Recommendation Report for Planning Permission for Works or Extension to a Dwelling

REF NO: R/52/20/HH

LOCATION: 32 Mill Lane
Rustington
BN16 3JN

PROPOSAL: Detached garage.

SCALE: 1:50, 1:100	DATE: MARCH 2020
DRAWING No: PBP1068/04	DRAWING SIZE: A2

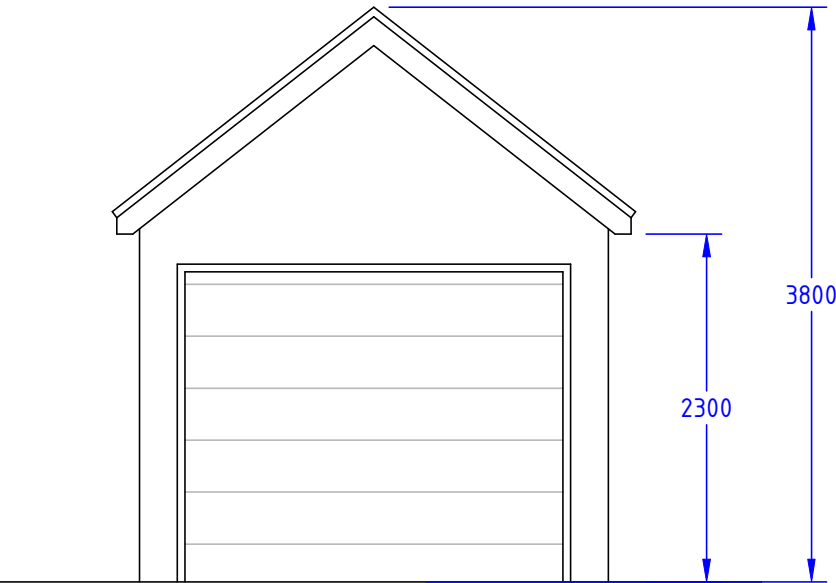
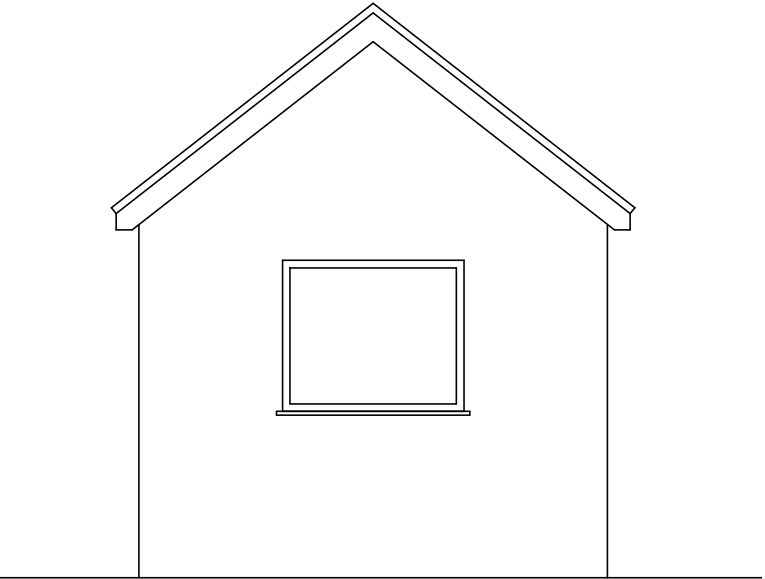
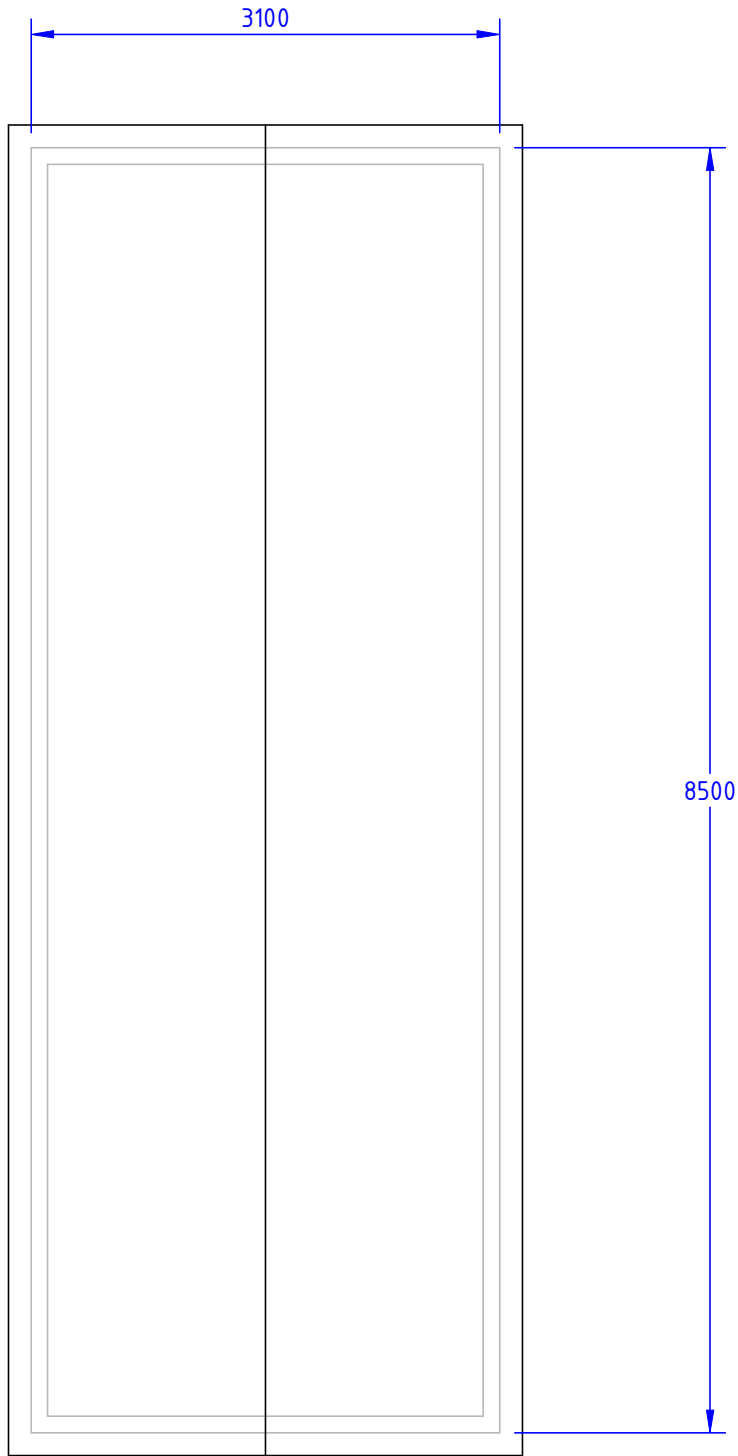
The garage will have a pitched roof and will be constructed of rendered blockwork. It is adjacent to a garage at No.34 and replaces one already in existence, although alters the roof design from flat to pitched.

The development will have eaves to 2.3m with a pitched roof to 3.8m. Whilst this is relatively tall the roof slopes away from the neighbouring property and due to the siting, it is considered a sufficient distance from the neighbouring property and is not deemed to give rise to any adverse overbearing or overshadowing impact.

There will be a door and window to rear and southern elevation of the garage however with the development at single storey, any views are considered to be of the garden of the host dwelling and not additional to that which can already be achieved.

BLOCK PLAN

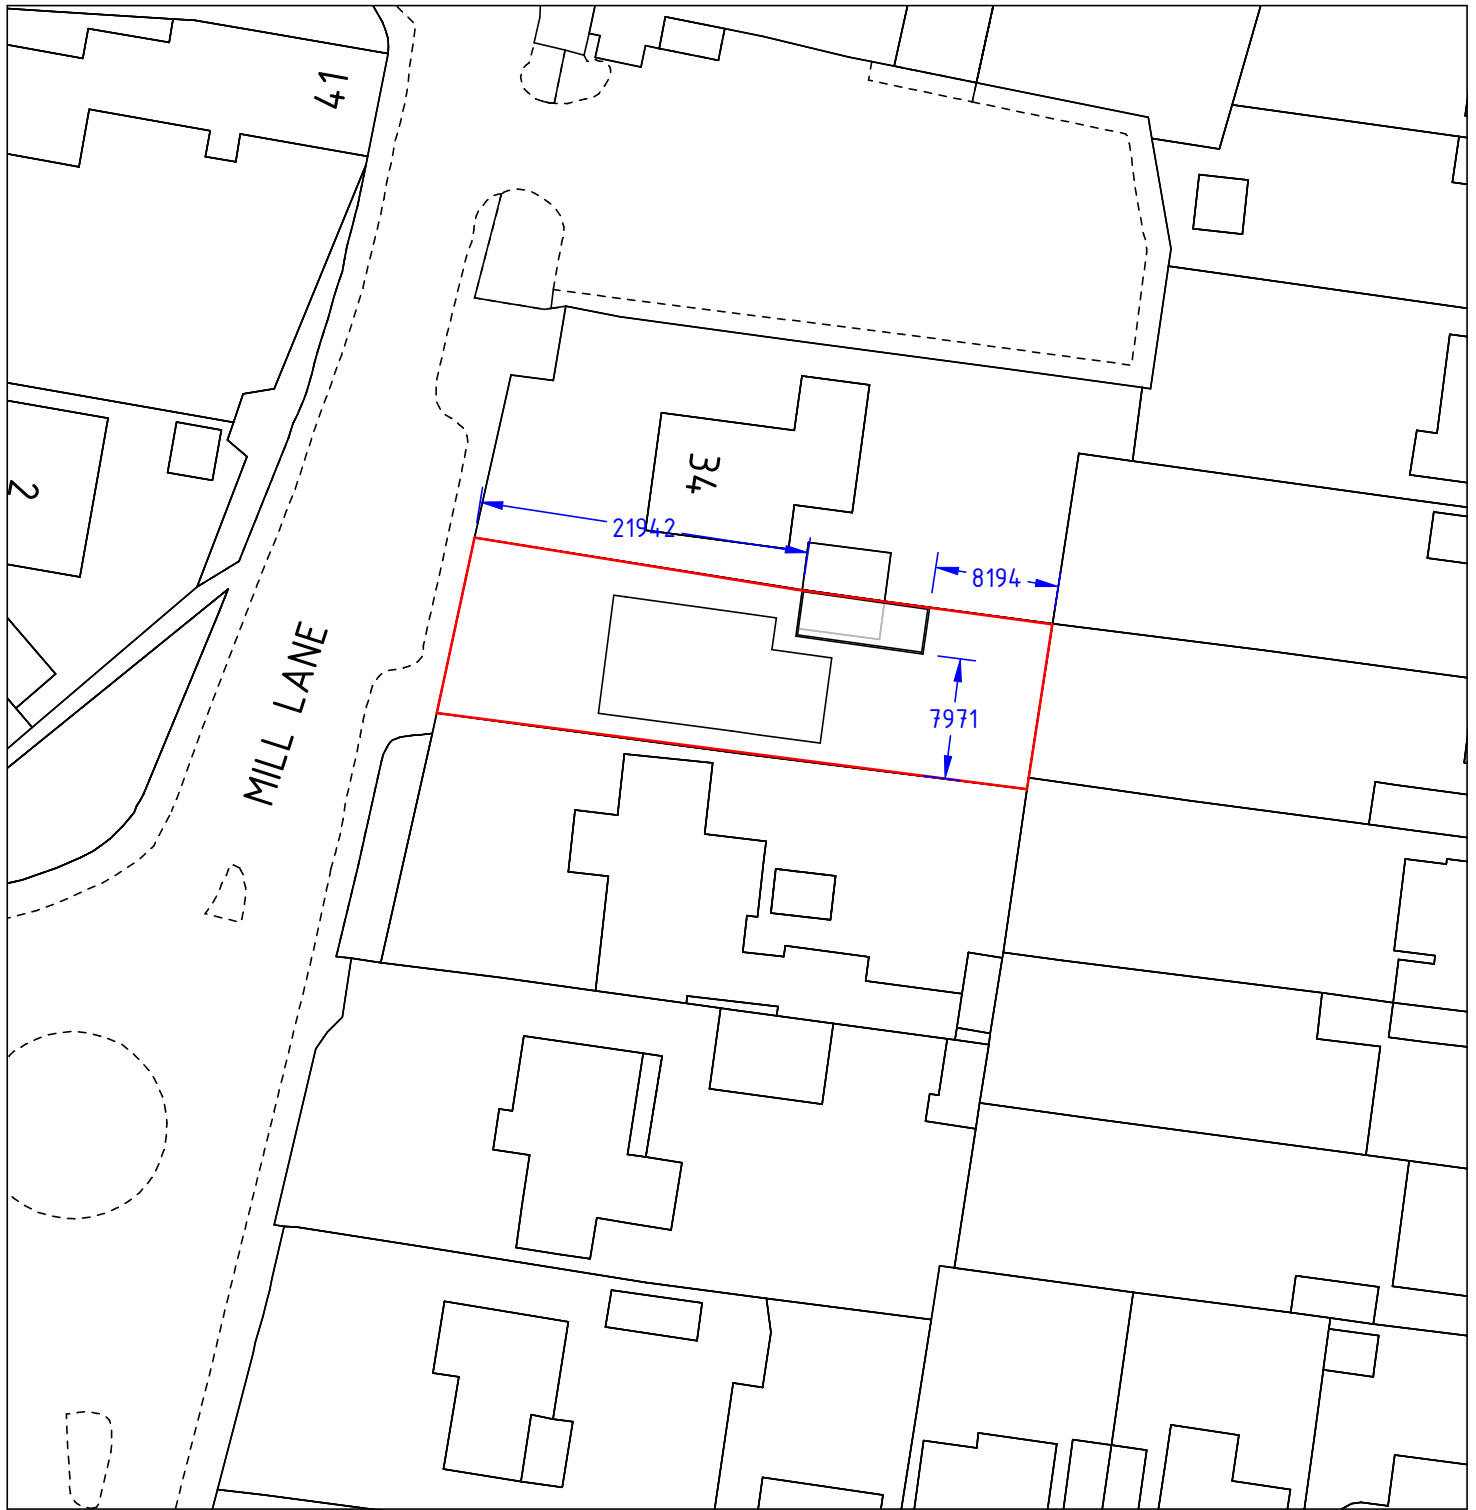
The garage will be situated 21m from the front boundary of the property and therefore the development will be visible from the street scene however with it set back it is not considered to appear unduly dominant.

The proposed garage is located to the north of the host dwelling and sits towards the rear of the property, extending beyond the rear elevation.

The garage will have a width of 3.1m and a depth of 8.5m. Whilst the depth is relatively large, the garage runs alongside a neighbouring garage which has a depth of 5.5m and therefore much of the view is restricted.
